GG119 ROAD SAFETY AUDIT RESPONSE REPORT

Project Title:	Blackmoorfoot Road, Huddersfield
Project Team:	Vistry, Miller, ARP and AMA
RSA Report Stage	Stage 1
RSA Organisation:	Optima
RSA Report Reference:	Blackmoorfoot Road, Huddersfield Proposed Access Arrangements Stage 1 Road Safety Audit May 2025 (Rev 1)
RSA Report Issue Date:	8 May 2025
Report Title:	GG1109 Designer's Response Report
Reference:	Rev 2

This Road Safety Audit Response Report relates to a Stage 1 Road Safety Audit carried out on the Blackmoorfoot Road / Felks Stile Road Highway Scheme in Huddersfield (Planning Application Reference 2020/92546 and S73 application 2024-92614 that relates to amendments to the site access conditions). The scheme comprises the construction of a new ghost island priority junction access onto Blackmoorfoot Road and simple priority junction on to Felks Stile Road, with associated works at the Blackmoorfoot Road/Felks Stile Road junction, and speed limit changes and signage improvements on Felks Stile Road and Blackmoorfoot Road. The site access on Blackmoorfoot Road will be in the form of a ghost island right-turn T-junction. The site access on Felks Stile Road will be in the form of a sim

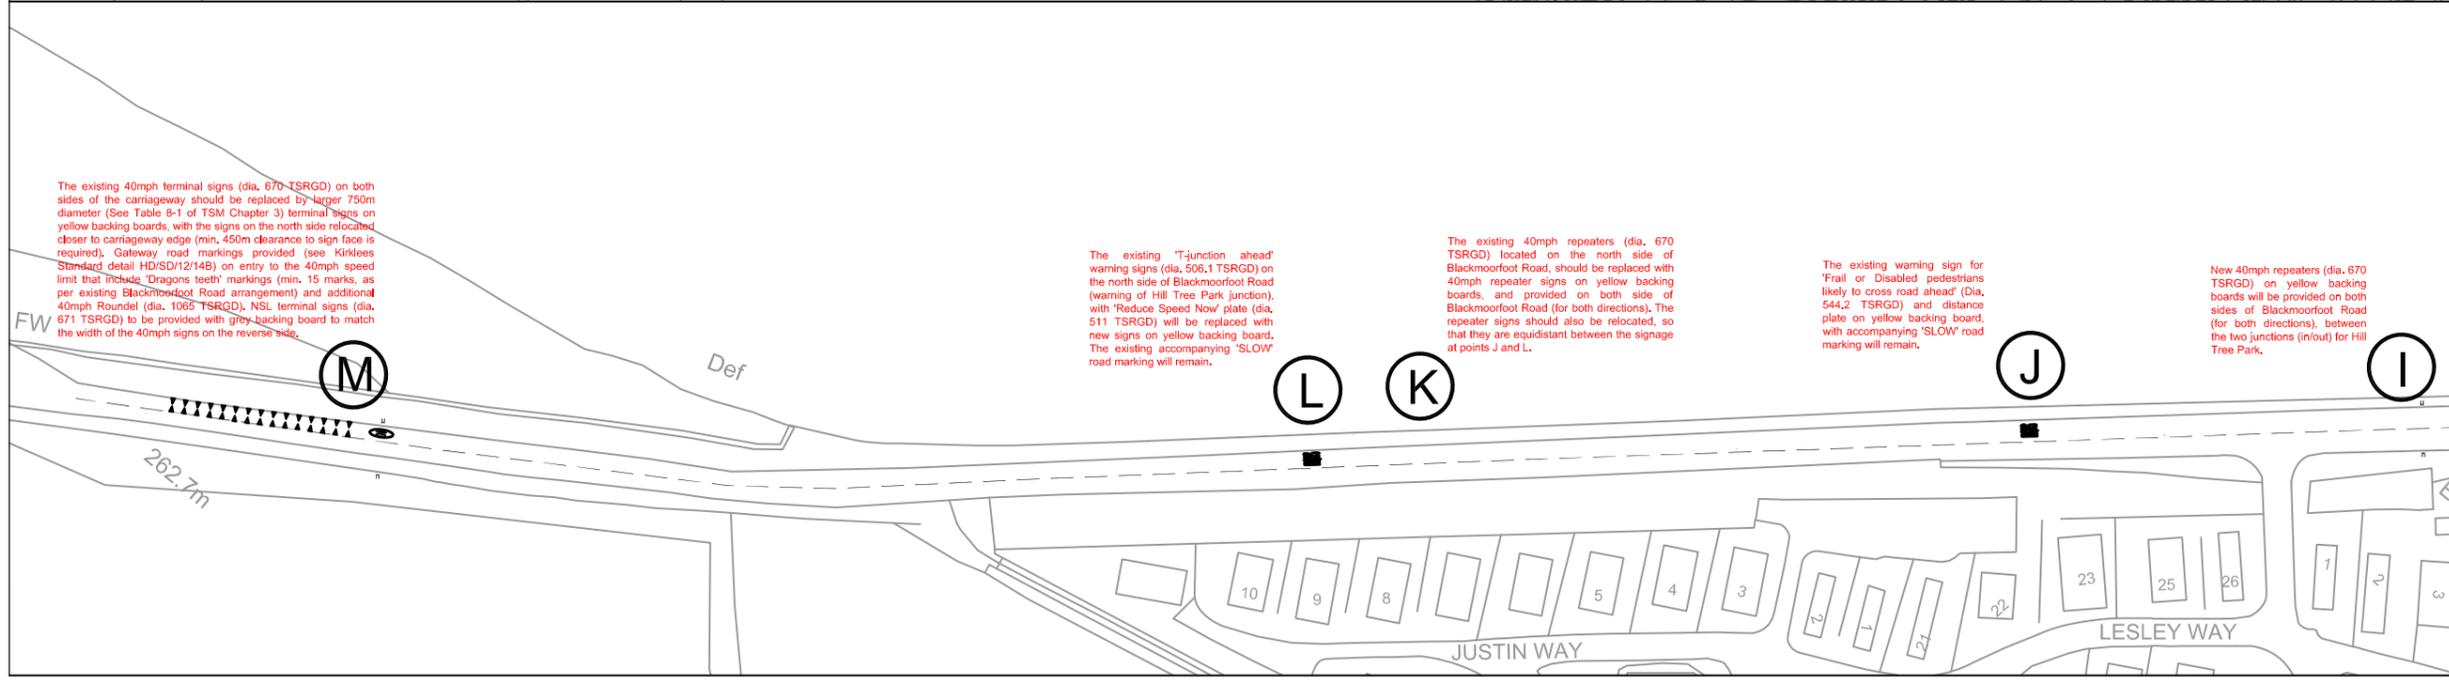
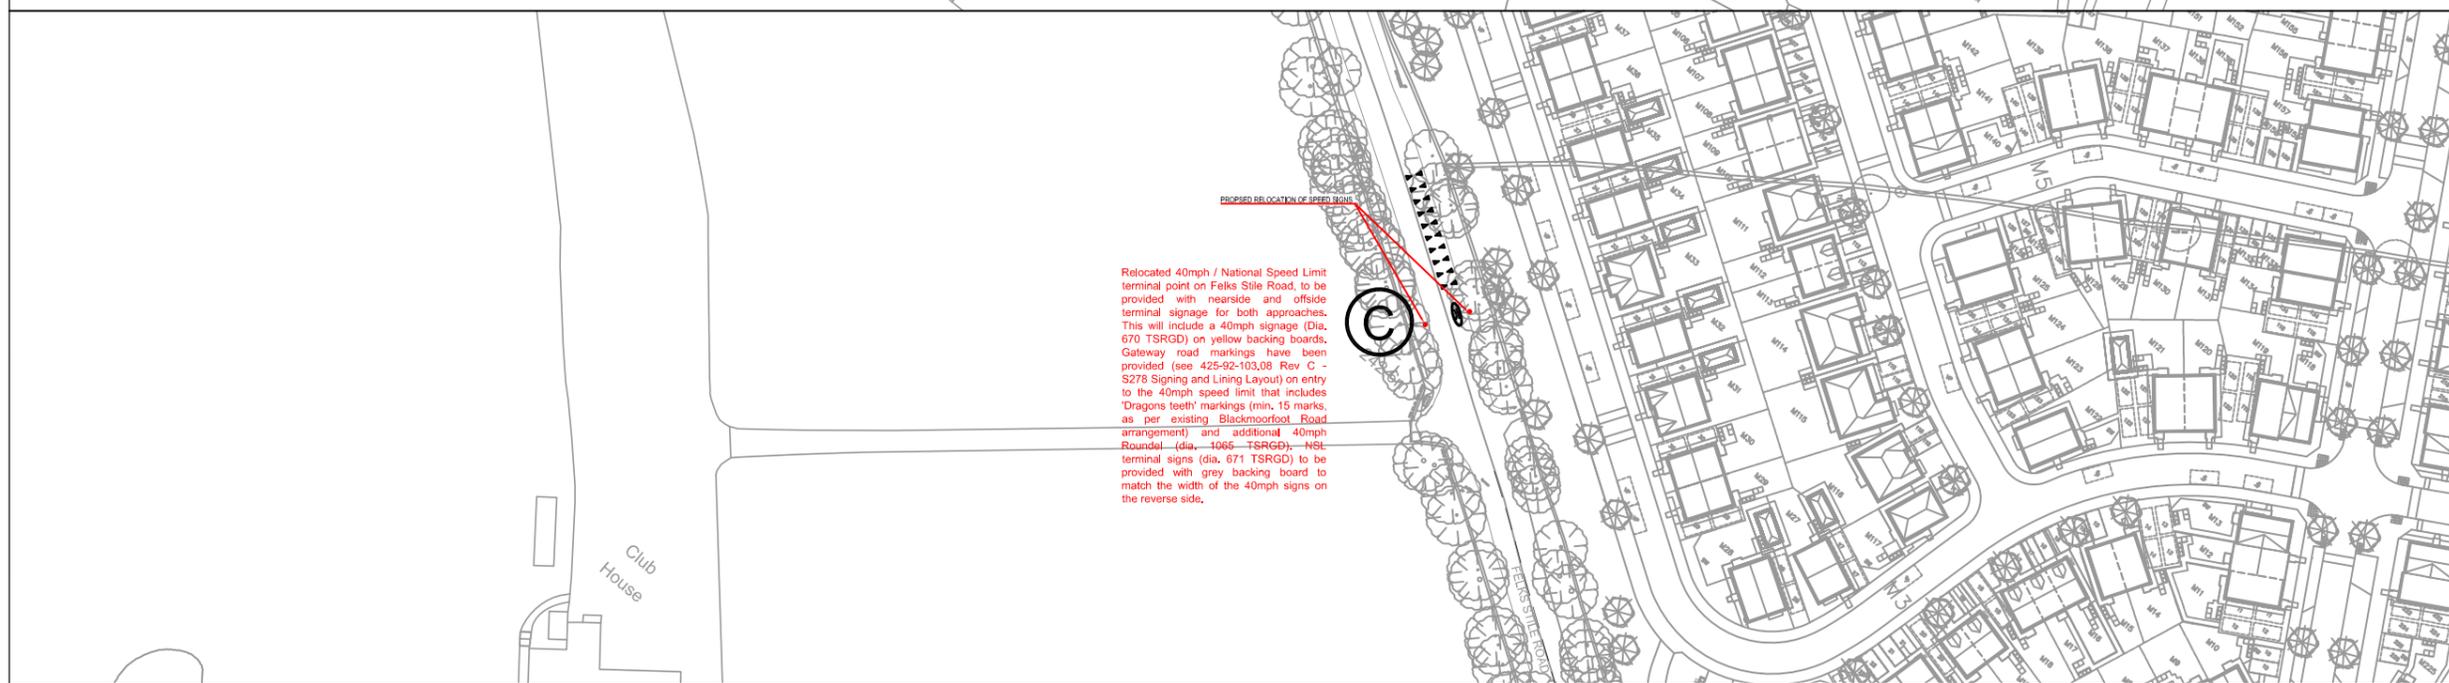
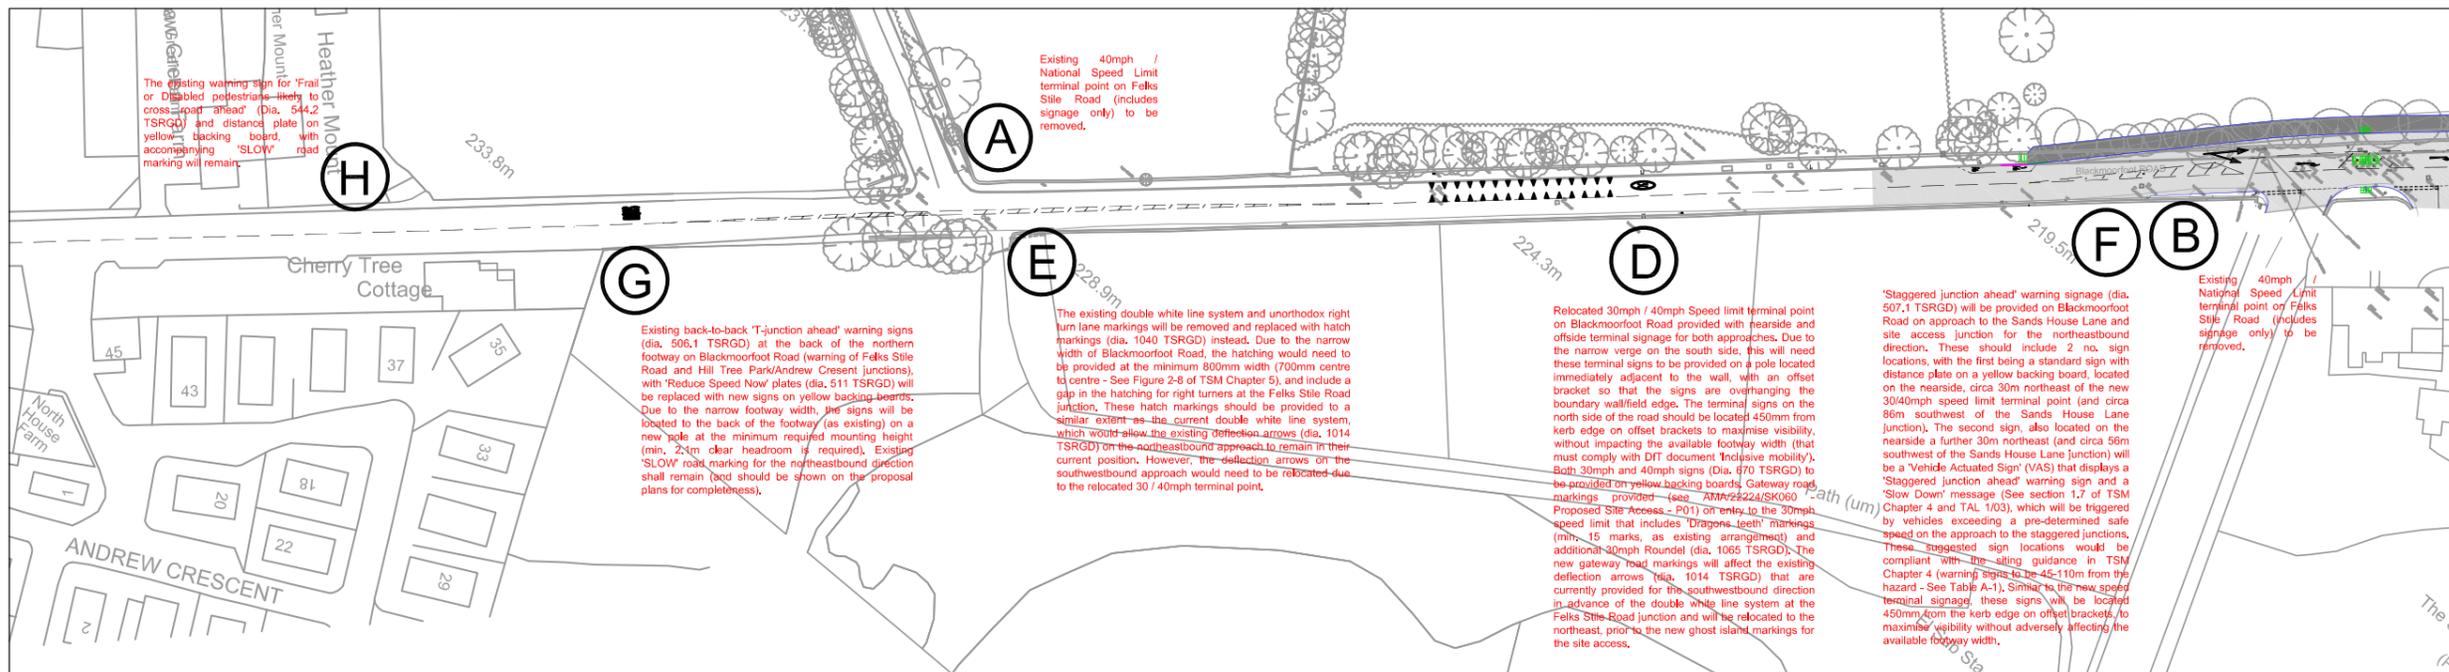
Summary: The splitter island may result in vehicle/cyclist collisions.

Detail: The proposed design includes a 1.2m wide splitter island intended to protect cyclists turning right from Blackmoorfoot Road into the development. Through lanes of 3.7m are provided adjacent to the splitter island.

Guidance contained within LTN 1/20 and Chapter 6 of the Traffic Signs Manual 'Traffic Control' state that lane widths between 3.2m and 3.9m should be avoided as it can encourage drivers to attempt unsafe overtaking of cyclists, when there is insufficient space to do so.

Whilst the Road Safety Audit Team agrees that the splitter island is an important feature of the scheme, as a consequence, westbound and eastbound cycle traffic could be 'squeezed' by drivers misjudging the passing clearance, resulting in a potential vehicle/cyclist collisions.

As such, it is recommended that either the right turn cycle facility and island are removed or additional measures are provided to discourage overtaking such as widening the island, providing red thermoplastic surfacing within the central hatching on both the approach to and around the island (to

visually reinforce the through lane width), provide road markings (cycle symbol for example) past the island to indicate a cyclists expected road positioning or whether warning signage could be provided.

Accepted. Red thermoplastic surfacing will be provided within the central hatching.

As such, the RSA Recommendation to provide red coloured surfacing within the central hatching on approach to the traffic island should be incorporated. For consistency, the coloured surfacing should be applied to the hatched tapers on both approaches to the ghost island markings.

In addition to the coloured surfacing, it is also considered that a central island beacon could be provided at the traffic island, to ensure it is conspicuous to approaching drivers. For consistency, a central island beacon should also be provided at the pedestrian refuge island also proposed on Blackmoorfoot Road as part of these works. However, these beacons should only be provided, subject to agreement with the street lighting team at the detailed design stage.

The site access layout drawing GA AMA/22224/SK060 P10 has been updated to indicate that coloured surfacing will be provided within the hatching; and that central island beacons will be provided on the traffic / refuge islands on Blackmoorfoot Road, with the notes confirming the provision of the beacons is 'subject to agreement with the Kirklees Street Lighting Team, at the detailed design stage'.

Summary: The width of the pedestrian refuge island may result in vehicle/cyclist collisions.

Detail: The side arm of the junction includes a 2.0m wide pedestrian refuge island, connecting to a 3.0m wide shared footway/cycleway along Blackmoorfoot Road. The Road Safety Audit Brief states that the reduced width of the island has been provided in order to minimise tree loss.

The swept path analysis confirms that both buses and refuse vehicles entering the development require the full width of the lane, with minimal margin for error, passing in very close proximity to the island.

Although the Road Safety Audit Team acknowledges that use of the island by larger bicycles may be limited, there is concern that the narrower island width could lead to vehicles encroaching on cyclists

using the island, if a cyclist (particularly a less experienced rider) does not position themselves entirely within the island, increasing the risk of a vehicle/cyclist collision.

It is recommended that the island is increased to 3.0m in accordance with LTN 1/20 guidance.

A 2m island width is considered appropriate in this location given the limited use that is likely to occur by cyclists. The SPA has been updated to show more clearly that the vehicles do not impact upon the refuge island when turning into the access.

Therefore, the refuge island should be widened to 2.5m, which is the minimum recommended width in DMRB (See CD143 – Table E/4.7). This should be achieved by setting back the kerb lines on either side of the minor road carriageway by circa 250mm, to ensure that the current lane widths on the minor arm are maintained; which should have minimal additional impact on the existing trees. Minor adjustment to the bus layby located in the site access road will also be required to accommodate these amended kerb lines.

The site access layout drawing GA AMA/22224/SK060 P10 has updated to include a 2.5m wide refuge island, and associated SPA drawings have been updated.

Summary: Pedestrians are encouraged to walk on the carriageway.

Detail: A new pedestrian refuge island is proposed between the development and the existing public house.

In order to accommodate the crossing, a short length of footway is proposed along the frontage of the public house, however this footway terminates before reaching both the vehicular access to the public house and the Blackmoorfoot Road/Sands House Lane junction. As a result, pedestrians accessing the public house must either walk within the bell mouth of the vehicular access or walk along the edge of the carriageway to reach the pedestrian access located along Sands House Lane. The absence of a suitable pedestrian connection may increase the potential for a pedestrian/vehicle collision.

It is recommended that the proposed footway is extended around the Blackmoorfoot Road/Sands House Lane junction, using the apparent unused area of the carriageway along the eastern flank of Sands House Lane, in order to connect with the existing pedestrian access to the public house.

Accepted. The design has been amended to provide a 1.5m footway along to initial northern section of Sand House Lane.

The site access layout drawing GA AMA/22224/SK060 P10 has been updated to include a 1.5m wide section of footway on Sands House Lane that terminates at the pubs pedestrian access. Appropriate dropped kerbs to be incorporated at the detailed design stage to allow access to the start of the footway at the pub accesses (both the pedestrian and vehicle accesses).
